Submission re Development Application for The University of Sydney Campus Improvement Program (CIP), State Significant Development (SSD 6123)

I write on behalf of Sydney Local Health District (SLHD), the owner and operator of Royal Prince Alfred Hospital (RPA), the direct neighbour on The University of Sydney's (UOS) western boundary, and therefore also on behalf of the NSW Ministry of Health/Health Administration Corporation.

01 HEALTH - SECTION 1 PROPOSED

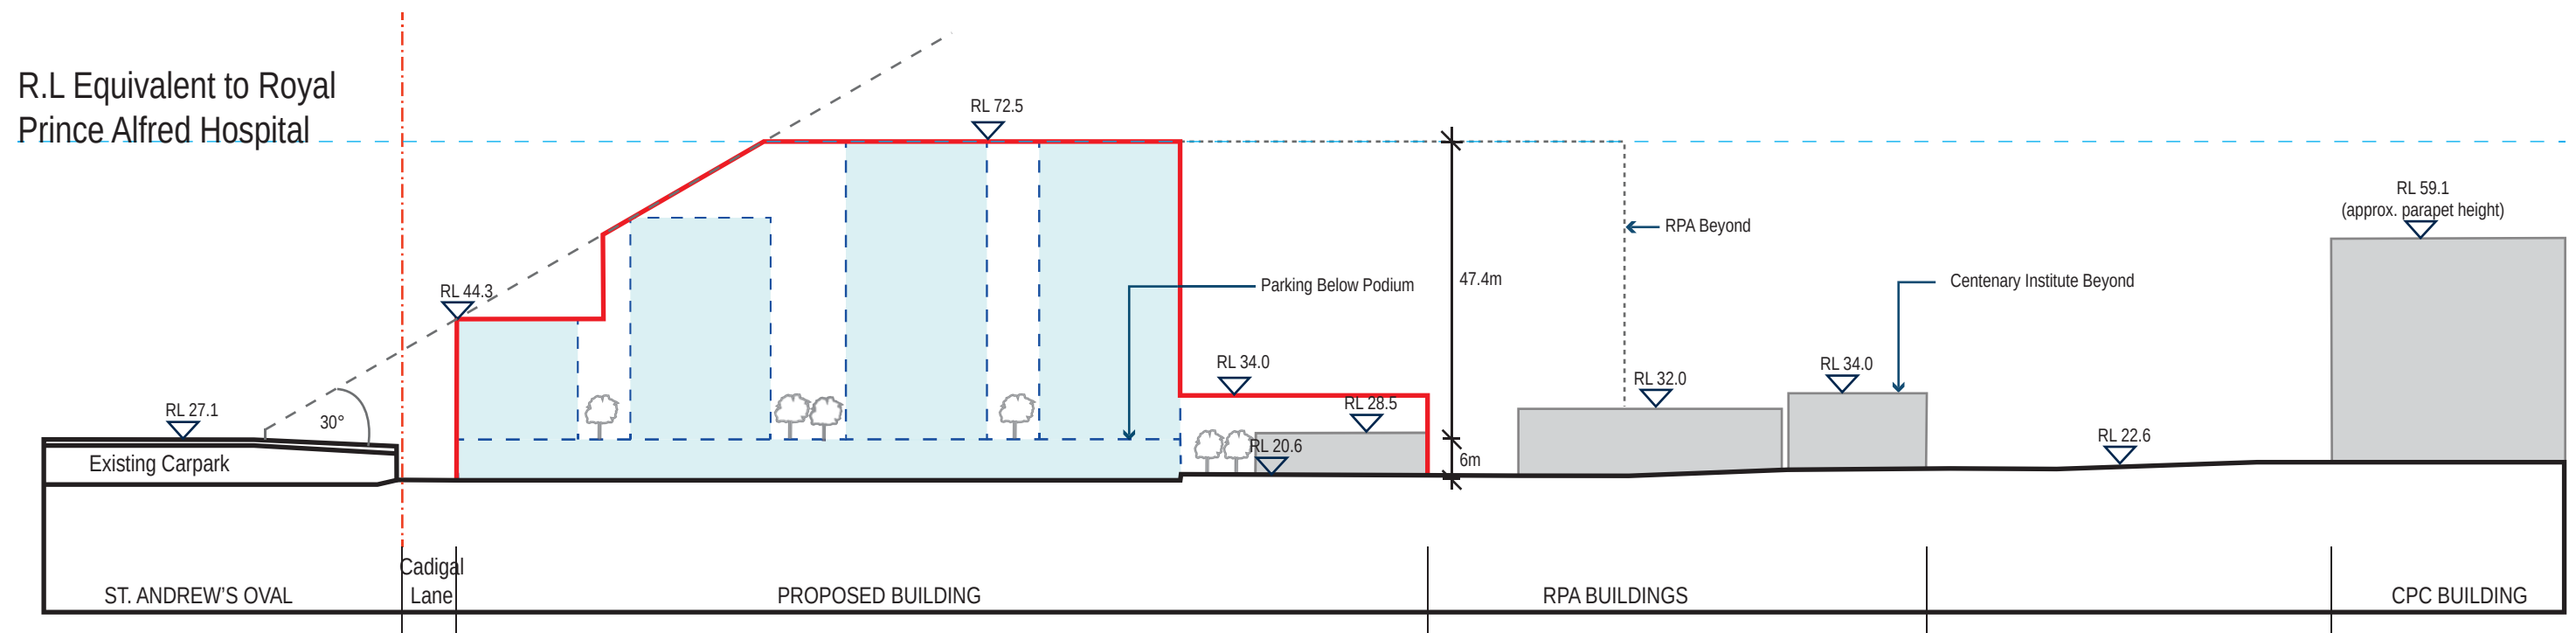
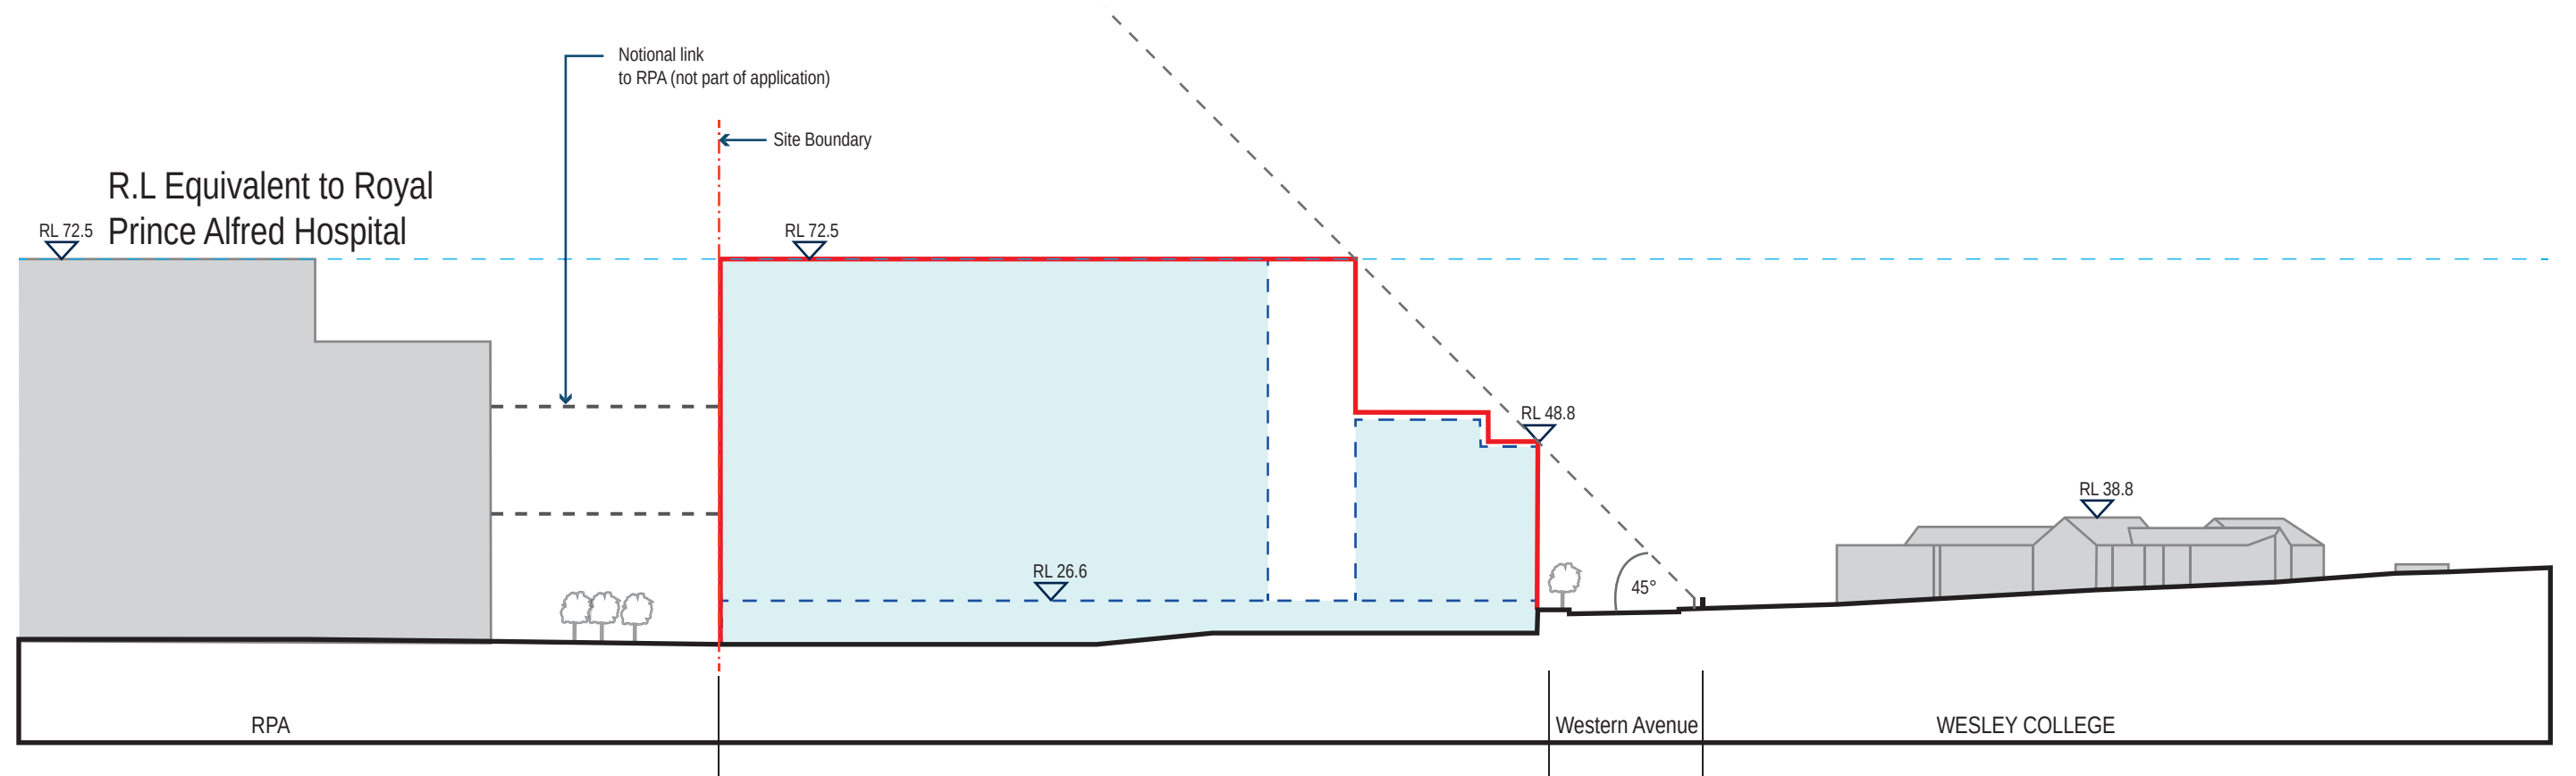
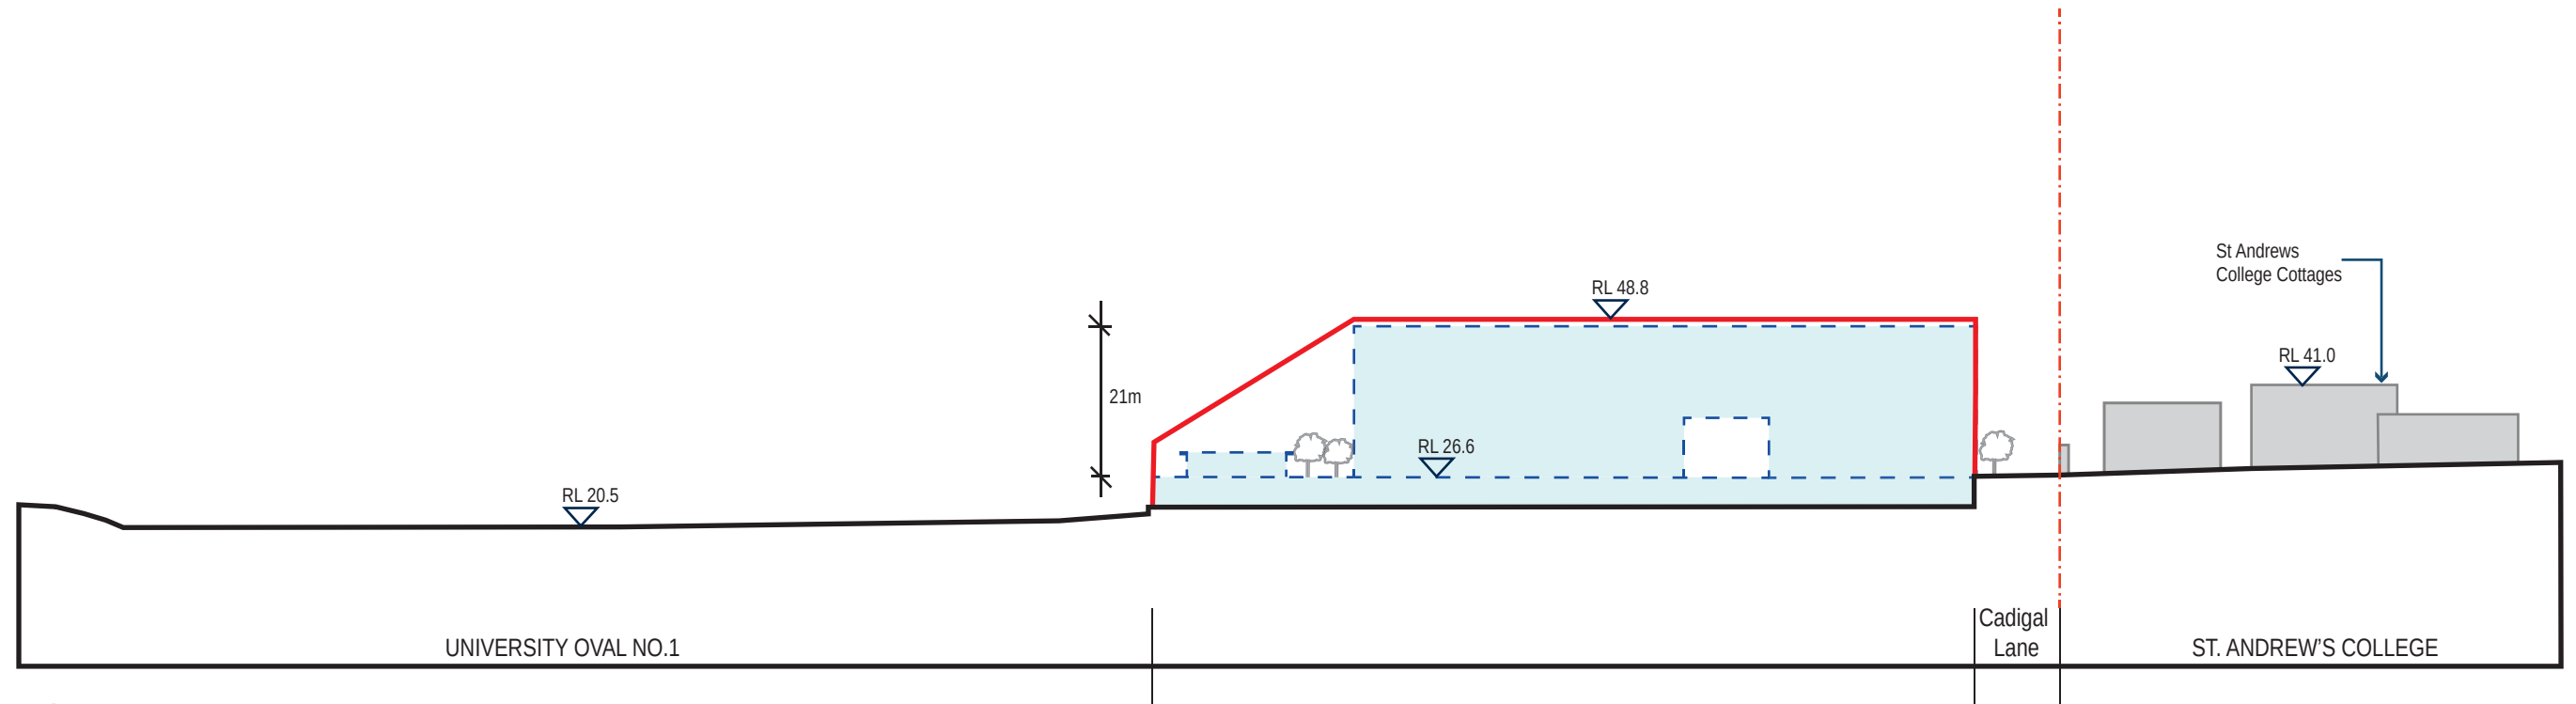
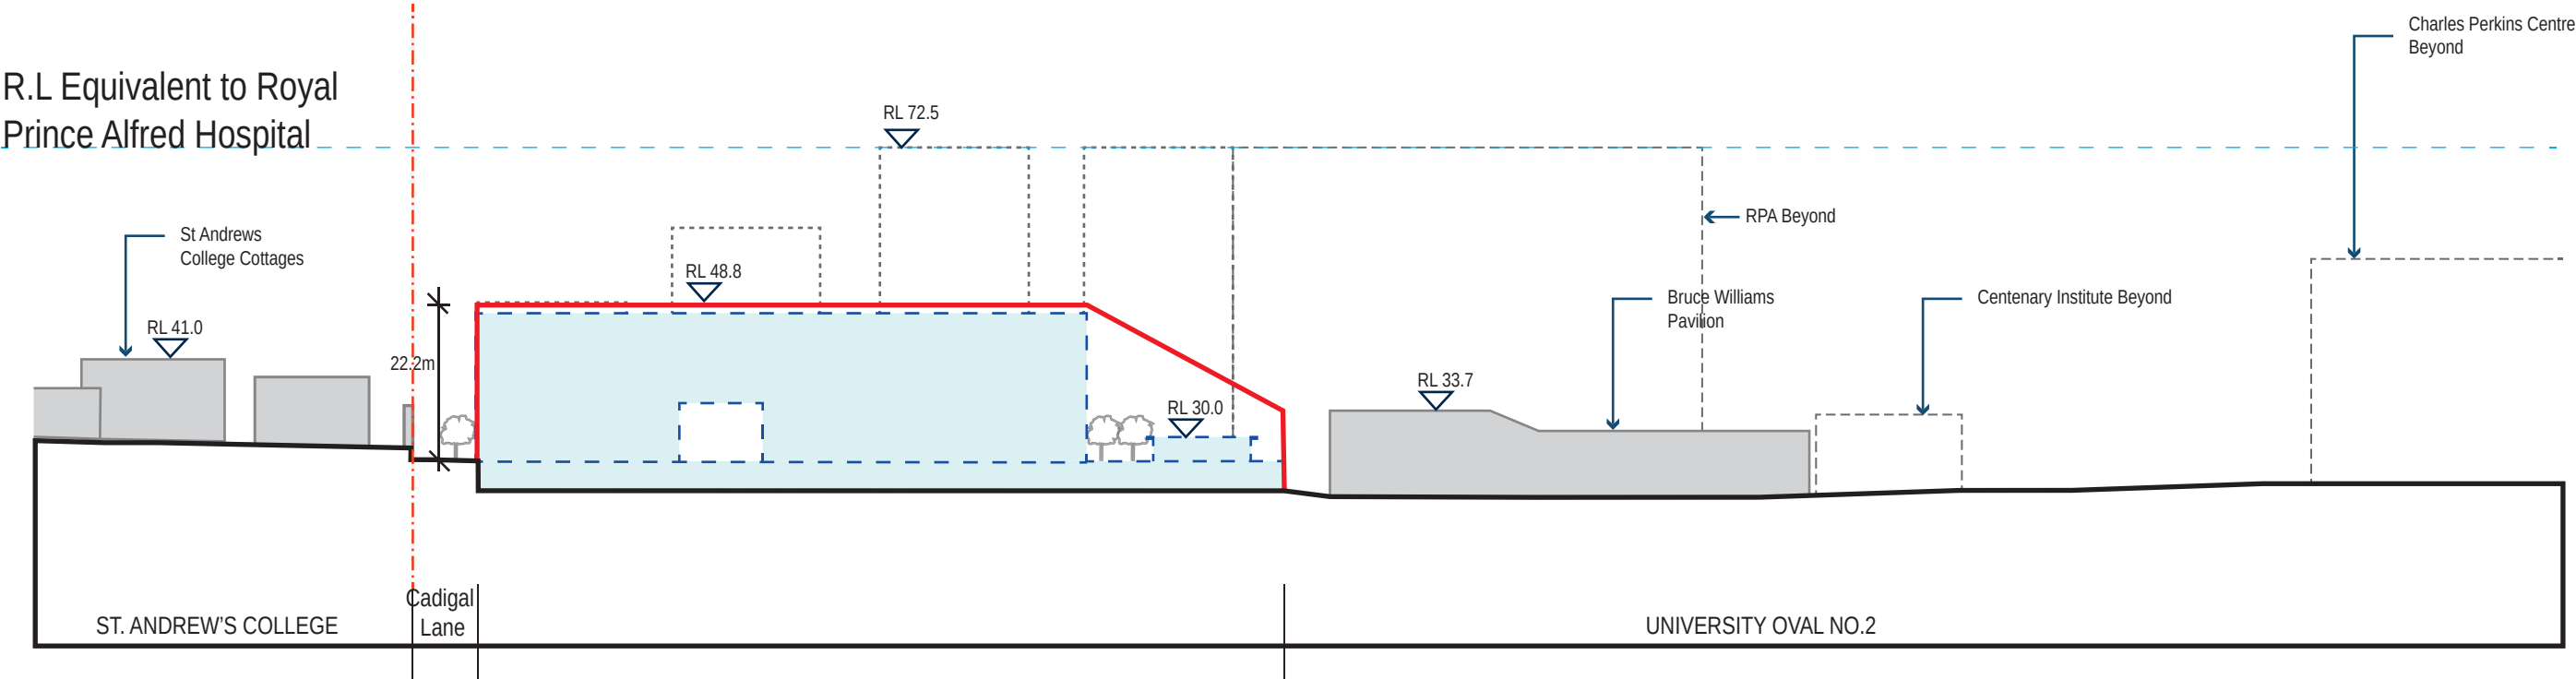
Building Envelope (refer Drwg No.s SSD-E-12 to 15 inclusive)

4. The proposed height of the building envelope is equivalent to the height of the Chris O'Brien Lifehouse on Missenden Road, seemingly putting the height of the proposed Health precinct buildings at RL77. This is not in our view appropriate given that there is a significant step-down in height from Missenden Road to the proposed Health Precinct, ie Lifehouse's ground floor starts approximately 3 to 4 levels higher. In short, the proposed height is out of context with surrounding RPA buildings, in particular Gloucester House and the CSB.

5. We assume it would be more appropriate for the proposed envelope height to be guided by, and respectful of, the surrounding building heights. Simply put, the imposing western facade of the Health Precinct appears inconsiderate to RPA (RL77 with no step-back, refer Drwg No. SSD-E-13) when compared with the step-back in height on its south-side to St Andrews (30 degree angle from RL44.3) and its east-side to UOS itself (45 degree angle from RL48.8). While the sections do not directly show Gloucester House which, as you would be aware, is a heritage-listed item, the proposed southern building appears to be respectful in height however we believe the envelope should also angle/step-back on its western aspect. We should also mention here, that there may be some considerations required in respect to the helicopter flight path if new buildings are higher than the existing RPA helipad which delivers emergency medical/surgical cases and forms an integral part of NSW's trauma response plans.

6. The proposal shows very tall and imposing buildings that would overwhelm and overshadow Gloucester House, the commemorative Courtyard and the RPA cafeteria in the trees. Naturally, we are concerned regarding the loss of solar access, not to mention inpatient views and staff/visitor amenity. The proposal, as currently presented, does not appear to satisfy the urban design principles outlined above.
